Sea Link Energy Cable

Appendix H4 to the Natural England Deadline 4 Submission

Natural England's Additional Comments on the Suffolk LVIA

10th February 2026

**Plate 3.2 Preferred area of acid grassland enhancement**

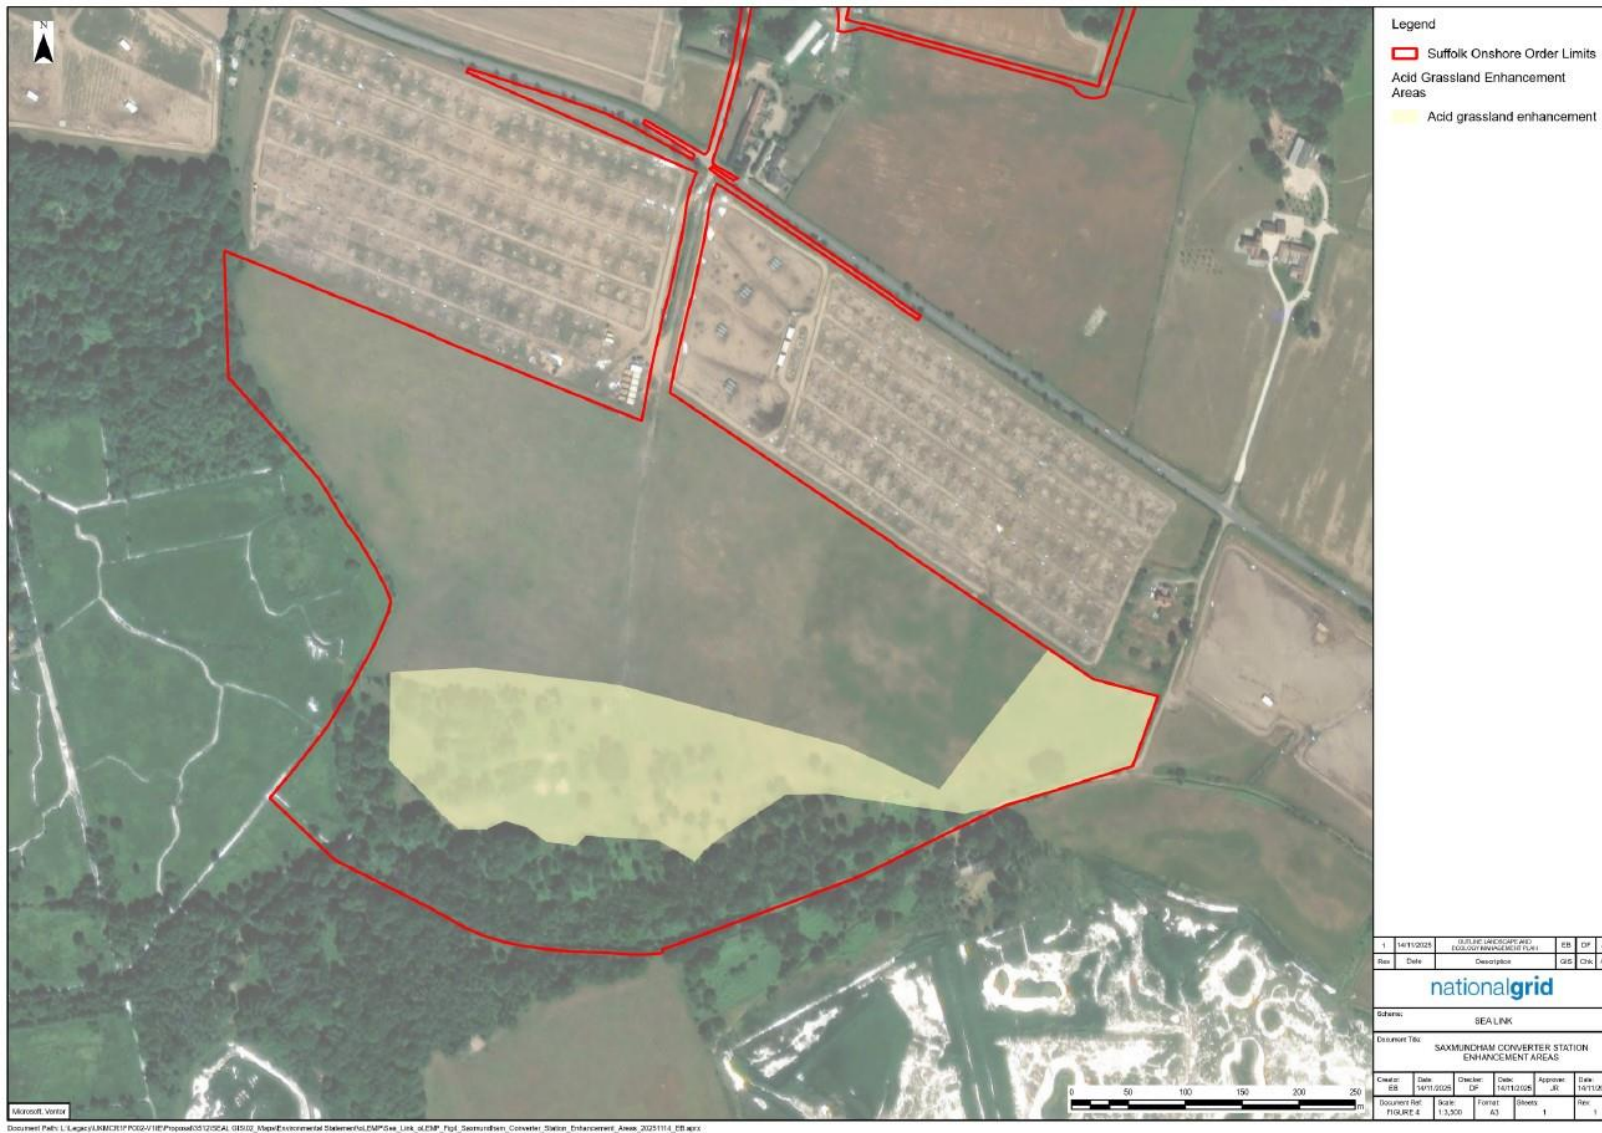
It is not clear how the 10-year management plan would be sufficient to provide the stated gains, either on ecological grounds or Landscape and Visual. This is a clear risk to the efficacy of compensation. Furthermore, the pre-commencement management of this area does not appear to be substantiated in the LEMP or Plate 3.2 within Document 9.47 [REP1-120].
